From: Sue Howell <Sue.Howell@arun.gov.uk>
Sent: 10 May 2021 17:39
To: Planning.Responses <Planning.Responses@arun.gov.uk>
Cc: Raymond Cole <Raymond.Cole@arun.gov.uk>
Subject: RE: Planning Consultation on: BN/18/21/RES

Application ref: BN/18/21/RES

Description: 5000 sq m of light industrial floor space (ClassB1 (b)/(c) following grant of outline planning permission WA/22/15/OUT (resubmission following BN/57/19/RES). This site is in CIL Zone 1 (Zero Rated) as other development.

Summary recommendation : Recommend approval of hard and soft landscape details contained within this BN/18/21/RES following grant of outline planning permission WA/22/15/OUT (resubmission following BN/57/19/RE

Client Rural Associates Project Title and Location GTR Factory Arundel Road, Fontwell, West Sussex			
Drawing Title Detailed Planting Plan Ornamental Planting			
Scale 1:100@A1	Drawn EZ	Approved DW	Date 30.01.20
Drawing No LLD1773-LAN-DWG-201			Revision 05

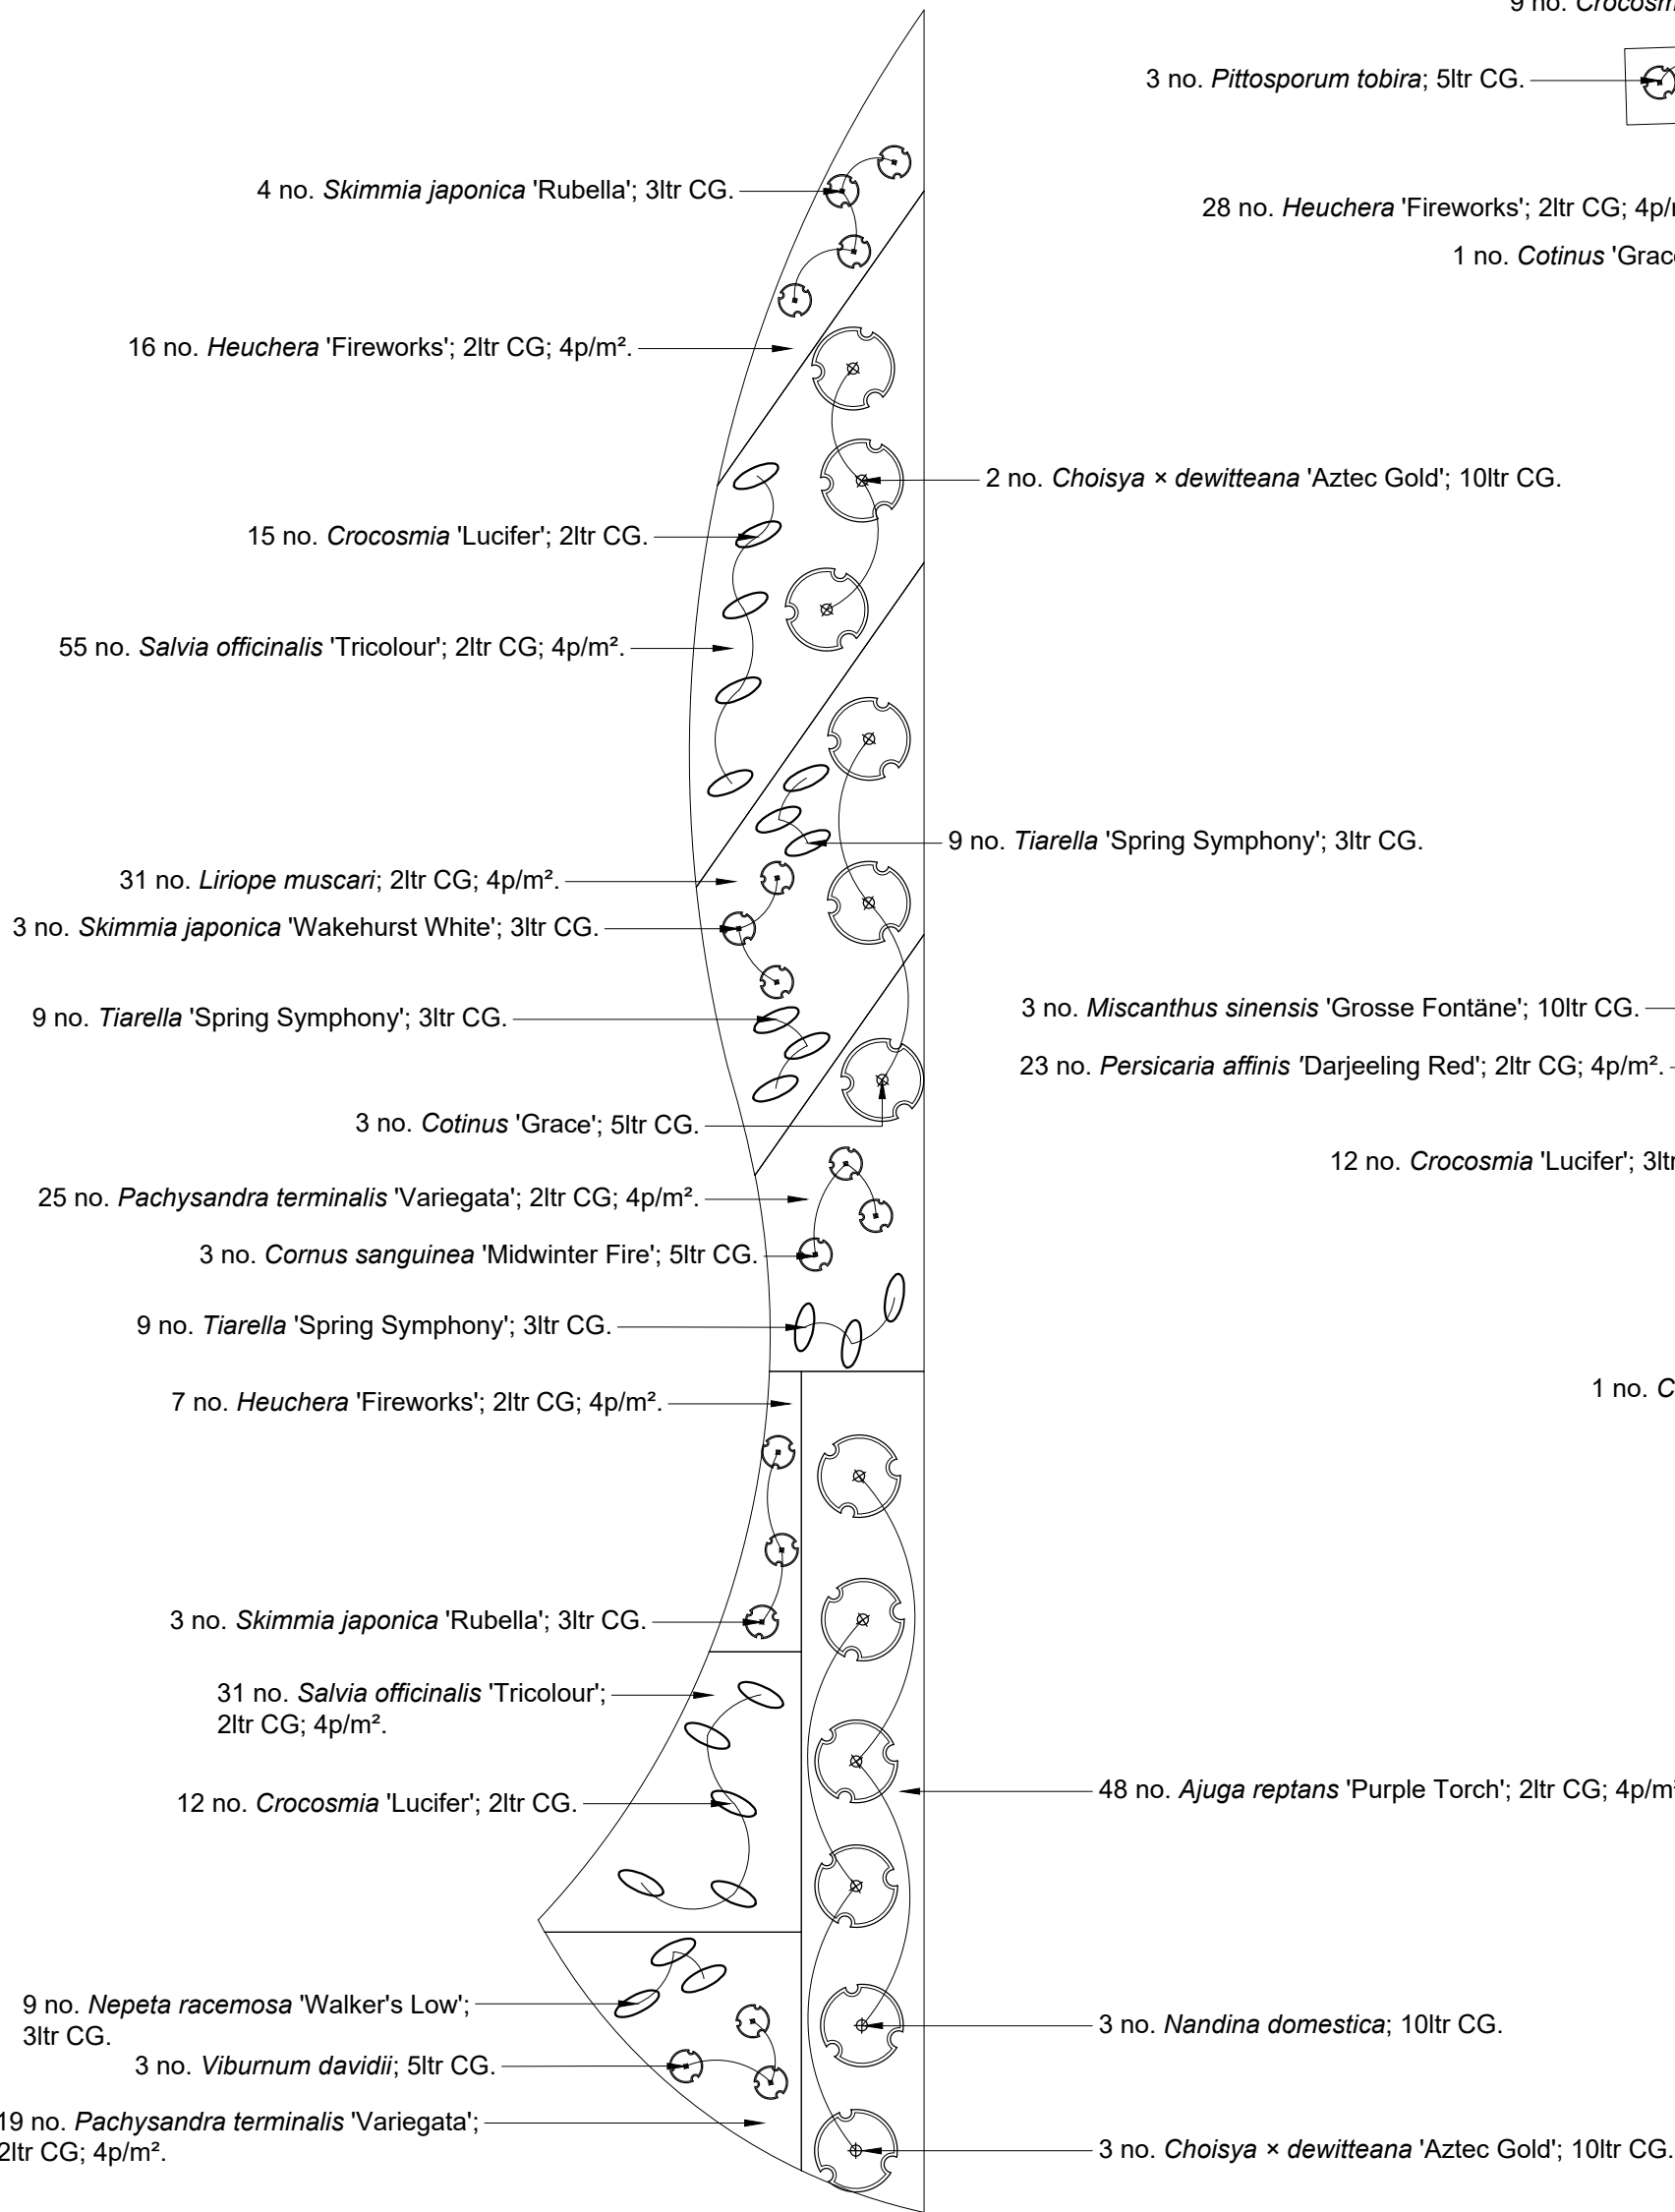
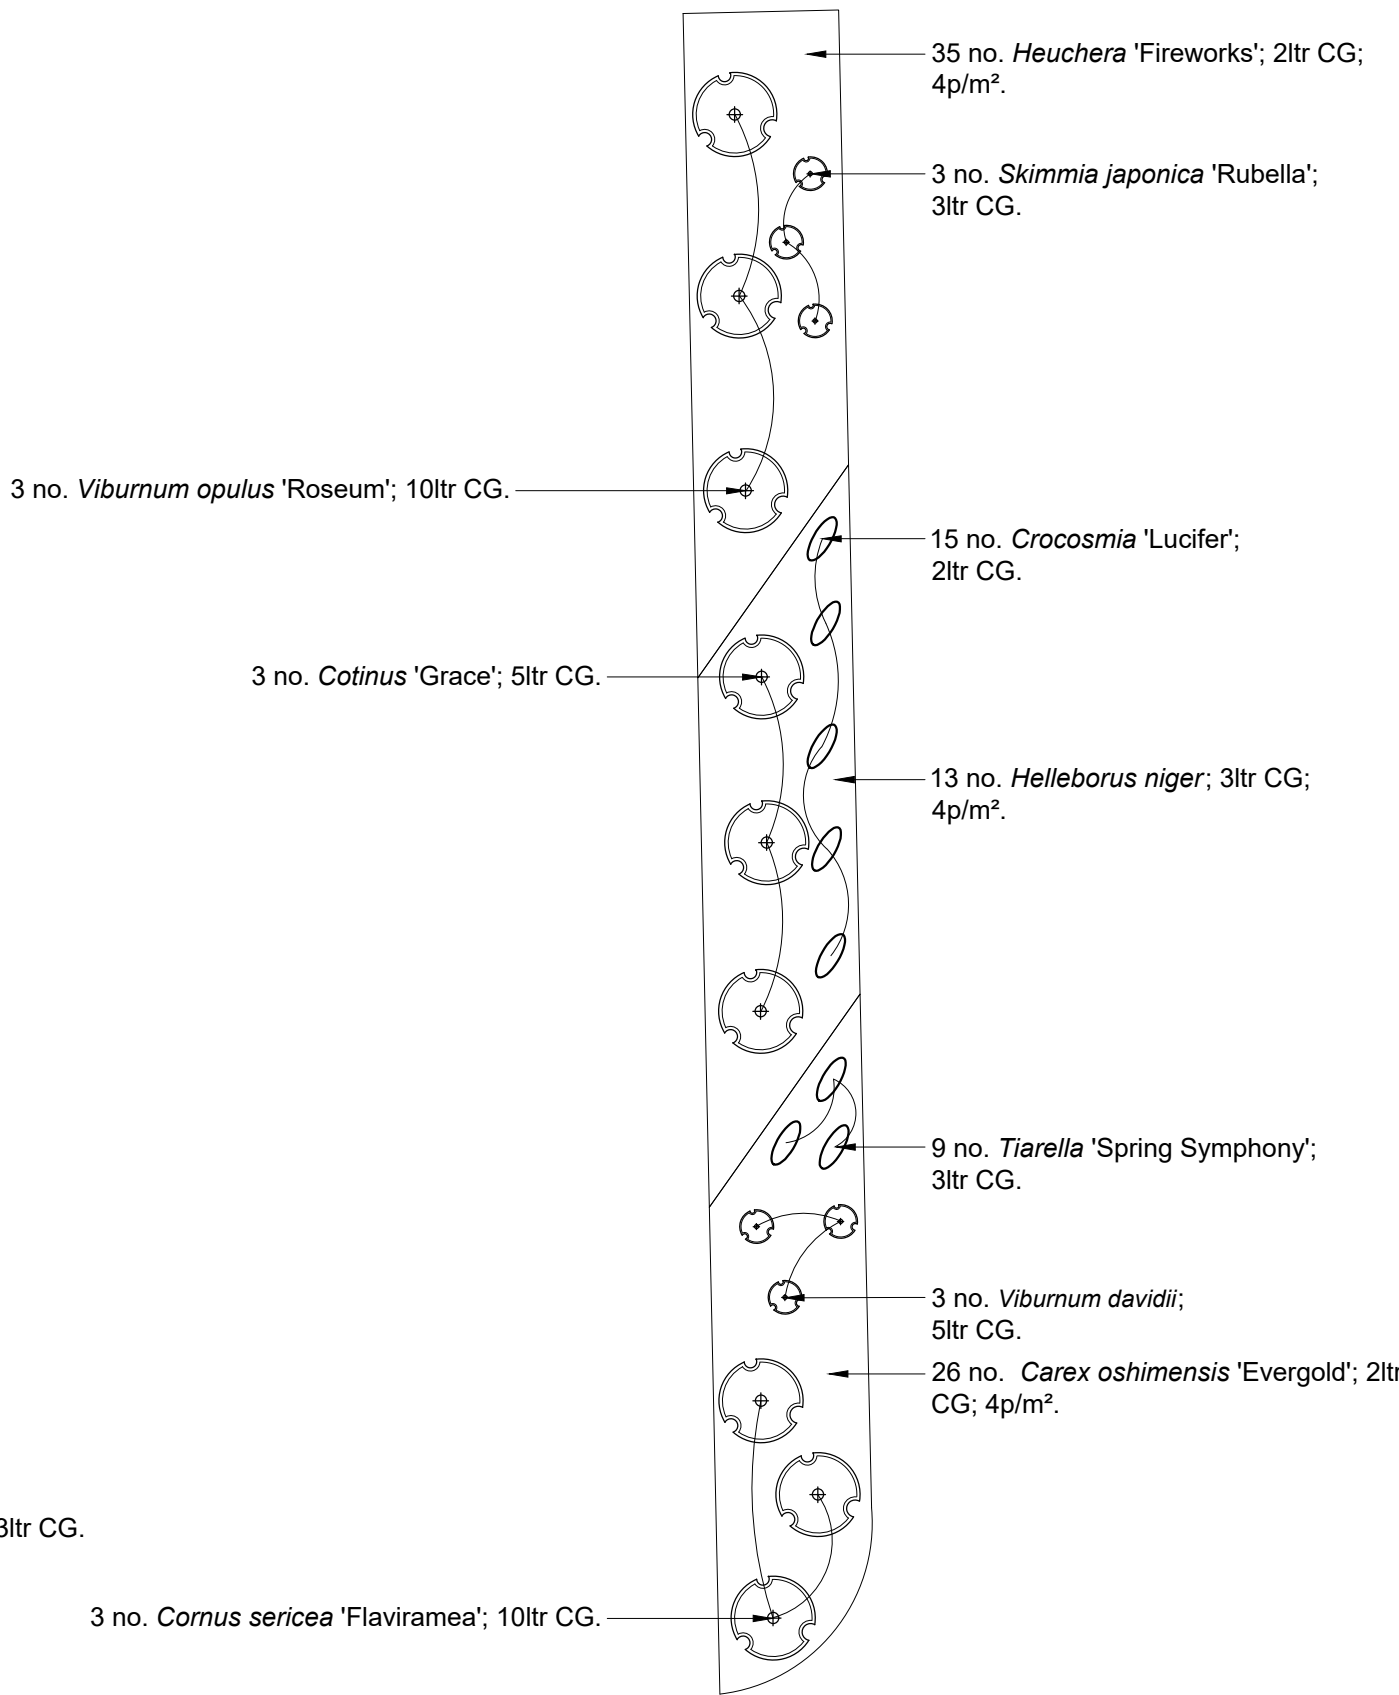
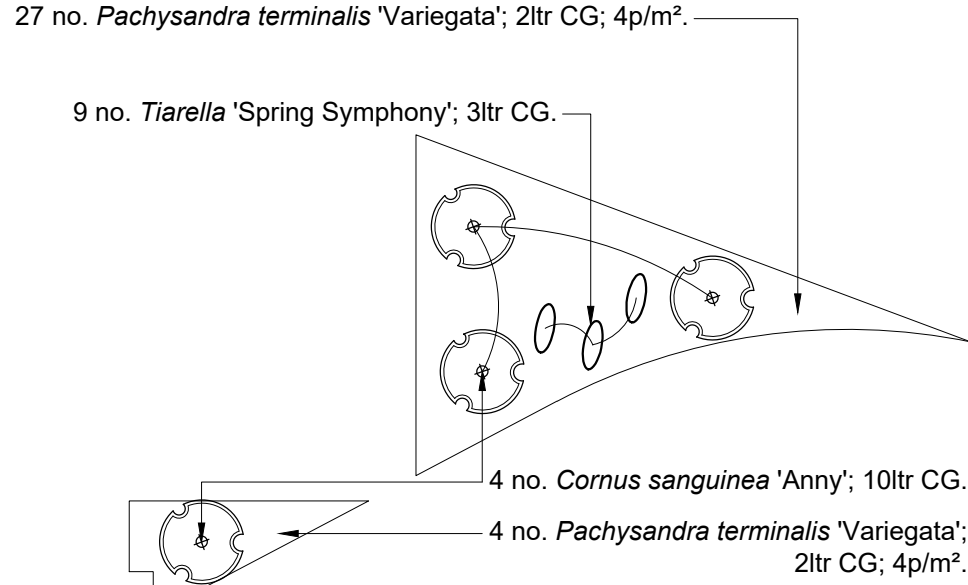
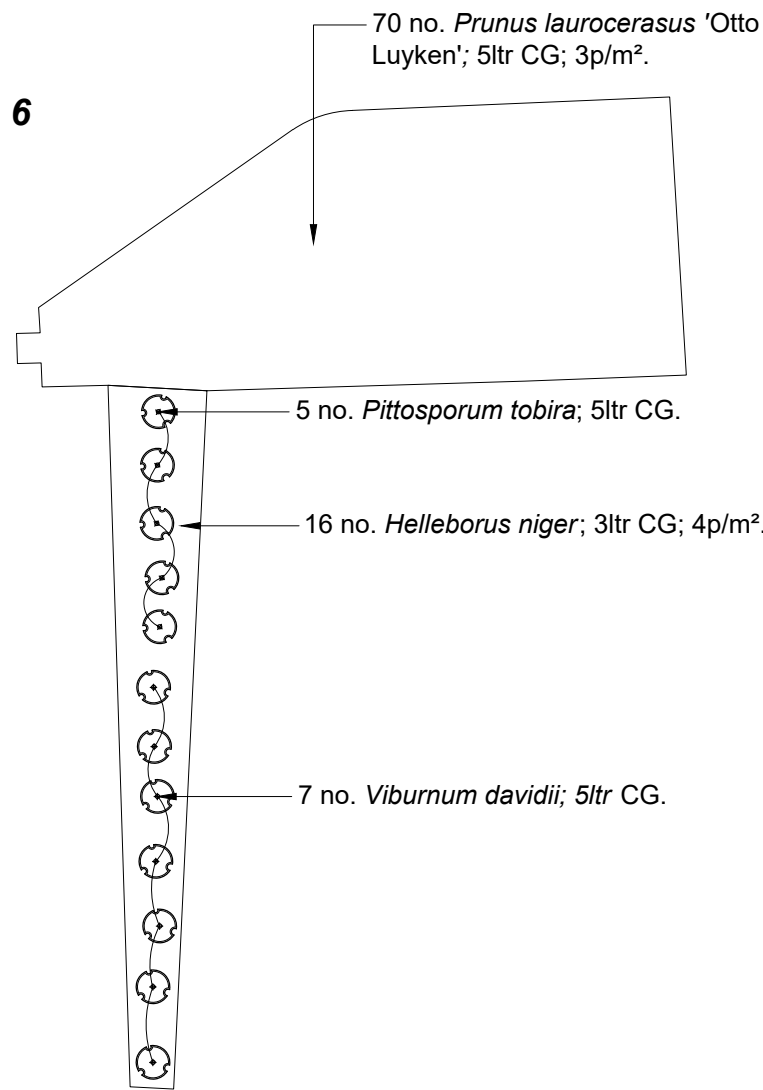
The information contained in Soft and Hard Landscape GA LLD-1773-LAN-DWG-100-REV10, Detailed planting plan ornamental planting LLD-1773-LAN-DWG-201-REV05, Detailed planting plan infrastructure planting LLD-1773-LAN-DWG-200-REV07, Detailed planting plan ornamental planting LLD-1773-LAN-DWG-202-REV04 proposes a well thought out and comprehensive scheme with trees, hedges, native planting, shrubs, grasses and buffer edge. The proposed scheme contains a good mix which will provide softening/screening improving the setting, increasingly over time as the planting matures. The scheme is adequately detailed with quantities and size at time of planting, providing trees which will add instant impact a species mix across the proposals both deciduous and evergreen which will add good biodiversity benefit to the site.
